City of Portland, Maine - Building or Use Permit Application
 389 Congress Street, 04101 Tel: (207) 874-8703, Fax: (207) 874-8716

Location of Construction: 81 RUBY LN	Owner Name: ST CLAIR GINA	Owner Address: 81 RUBY LN	Phone:
Business Name:	Contractor Name: property owner	Contractor Address: Portland	Phone
Lessee/Buyer's Name	Phone:	Permit Type: Additions - Dwellings	Zone:

Past Use: Single Family	Proposed Use: Single Family 6' x 8' shed	Permit Fee: \$30.00	Cost of Work: \$1,400.00	CEO District: 5
Proposed Project Description: 6' x 8' shed		FIRE DEPT: <input type="checkbox"/> Approved <input type="checkbox"/> Denied	INSPECTION: Use Group: Type	
		Signature:	Signature:	
PEDESTRIAN ACTIVITIES DISTRICT (P.A.D.)				
Action <input type="checkbox"/> Approved <input type="checkbox"/> Approved w/Condition <input type="checkbox"/> Denied				
Signature: Date:

Dept: Zoning **Status:** Approved with Conditions **Reviewer:** Marge Schmuckal **Approval Date:** 08/24/2007
Note: **Ok to Issue:**

25' NO CUT ZONE

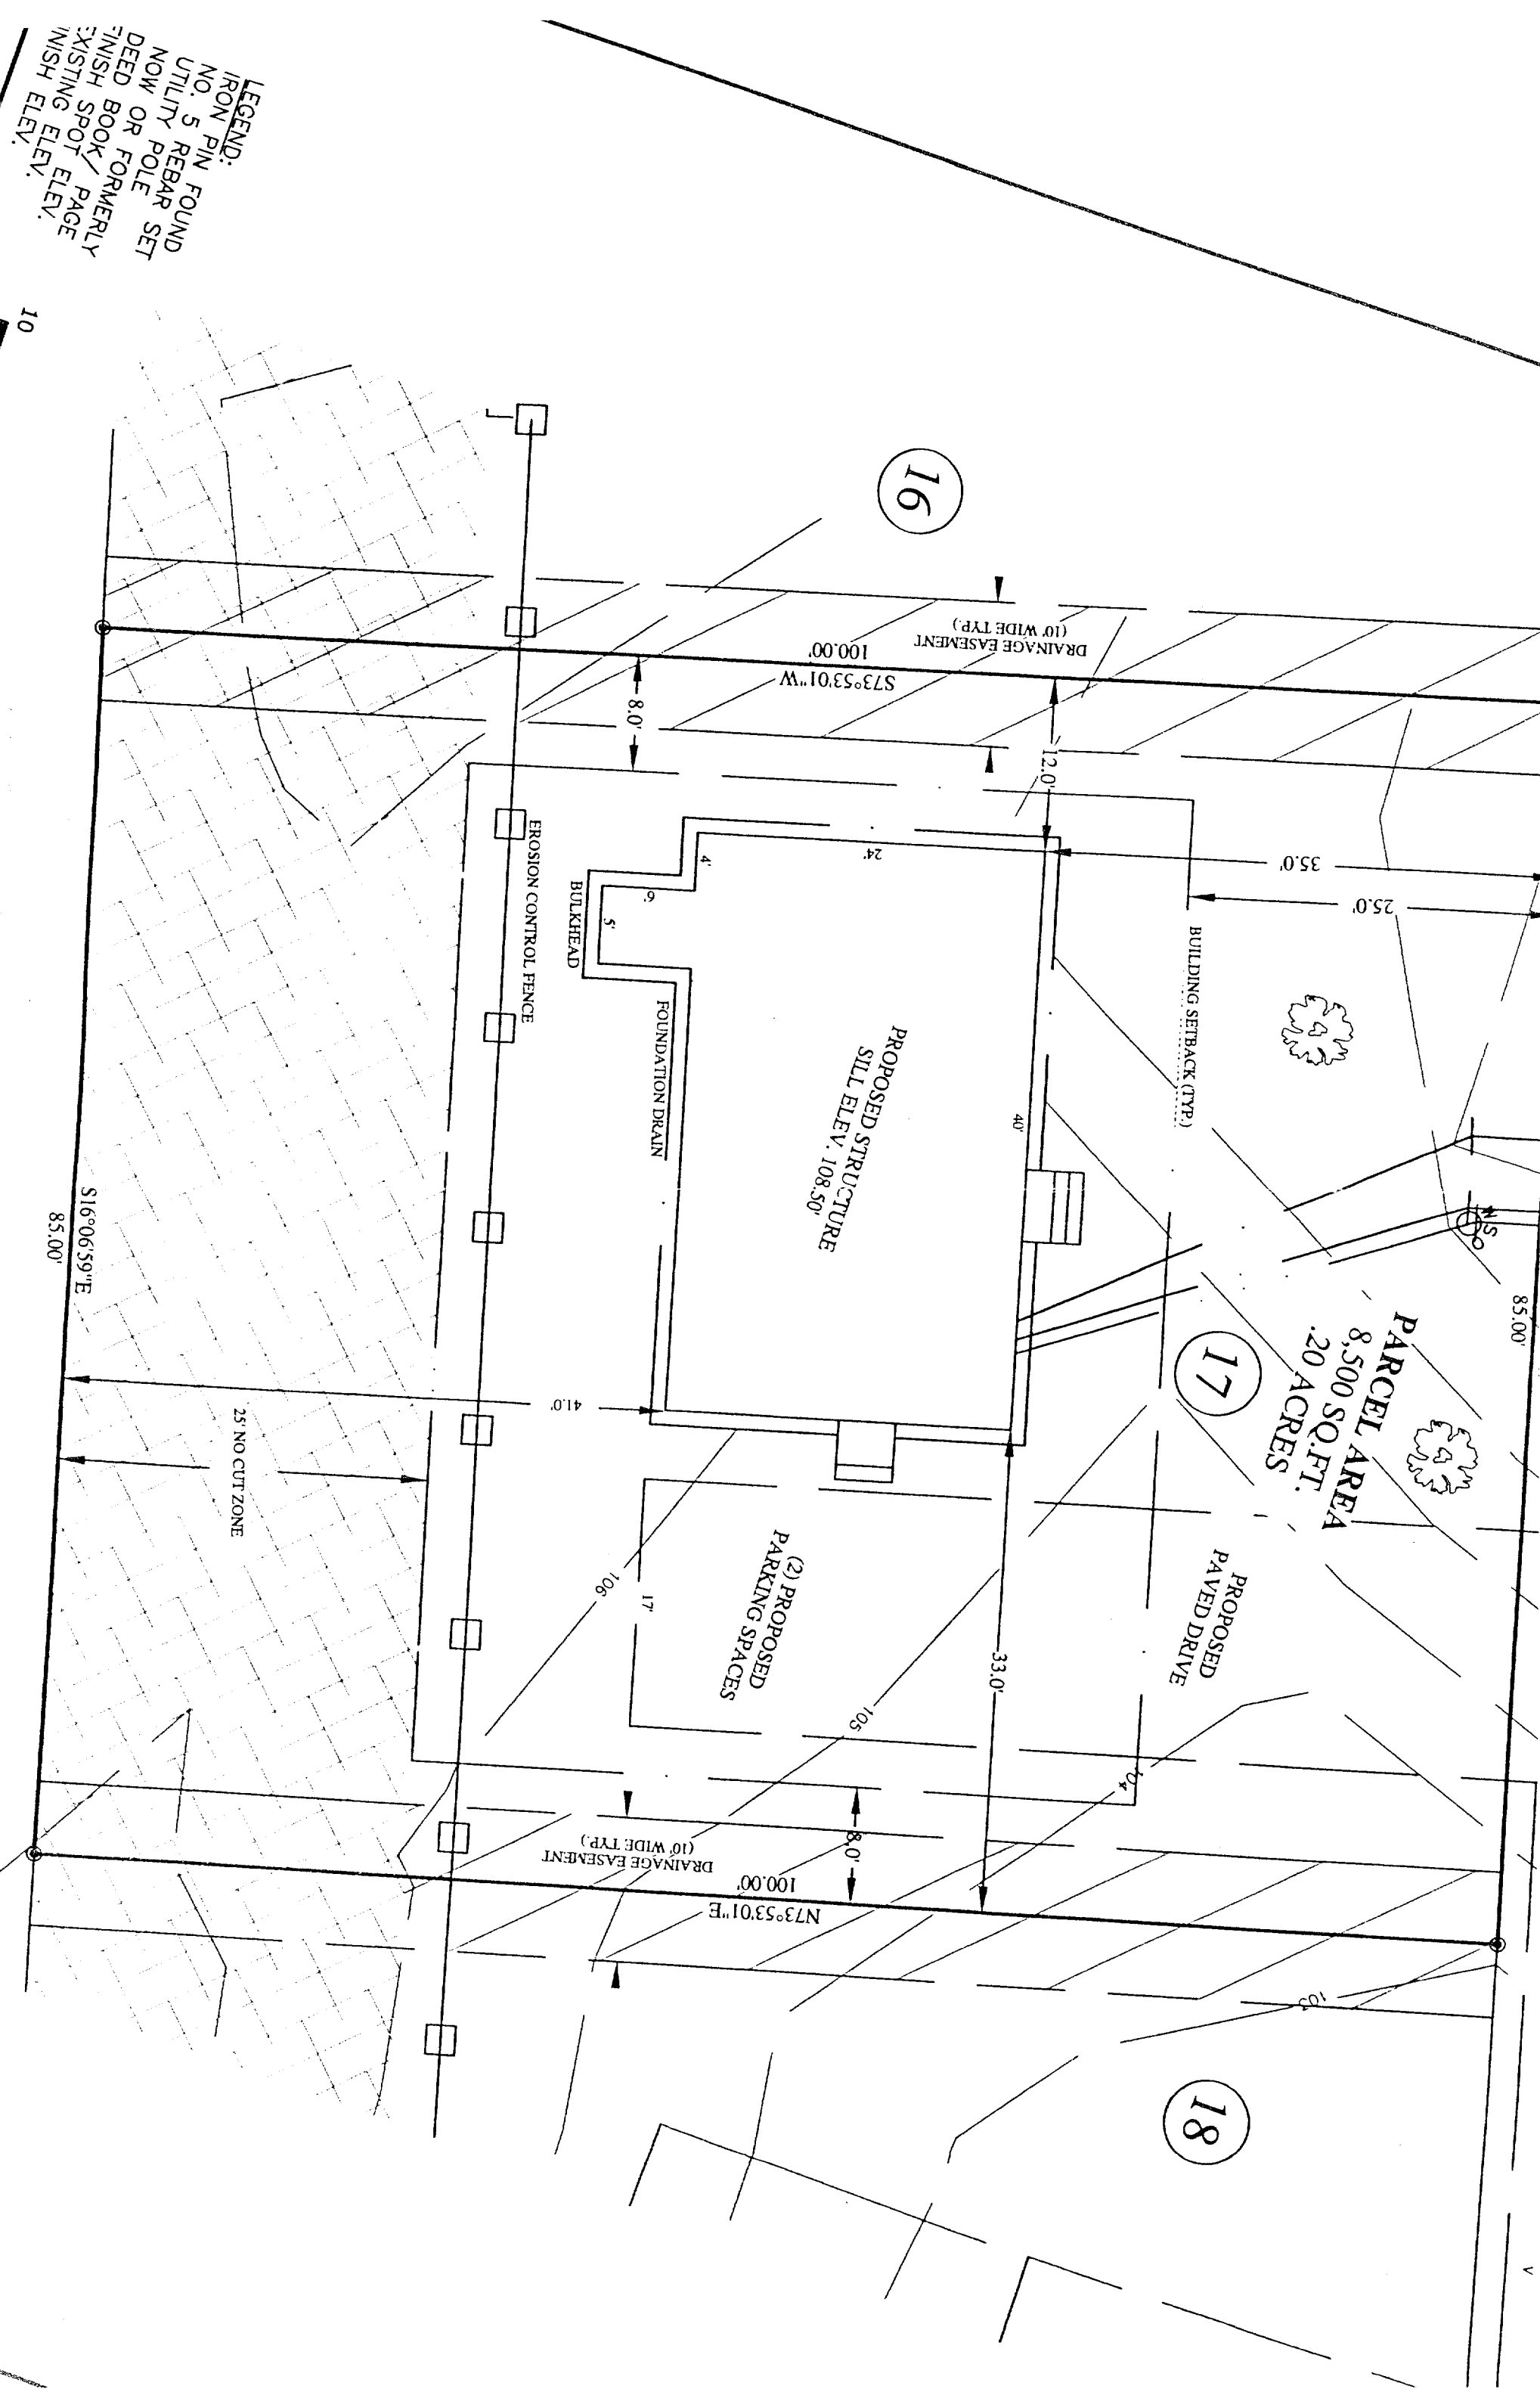
- 1) Separate permits shall be required for future decks, sheds, pools, and/or garages.
- 2) This permit is being approved on the basis of plans submitted and conversations confirming that the shed will be at least 25' from the rear property line to be placed outside of the 25' no cut area placed on the property by the PB. Any deviations shall require a separate approval before starting that work.
- 3) This property shall remain a single family dwelling. Any change of use shall require a separate permit application for review and approval.
- 4) This is NOT an approval for an additional dwelling unit. You SHALL NOT add any additional kitchen equipment including, but not limited to items such as stoves, microwaves, refrigerators, or kitchen sinks, etc. Without special approvals.

8/24/2007-mes: On 8/21/07 I called the owner - the shed will be located within a rear 25' wide no cut area placed on this property by the PB. She returned the call saying she would place the shed at least 25' from the rear property line and be outside of the no cut area. She will send me a note/plan confirming that.
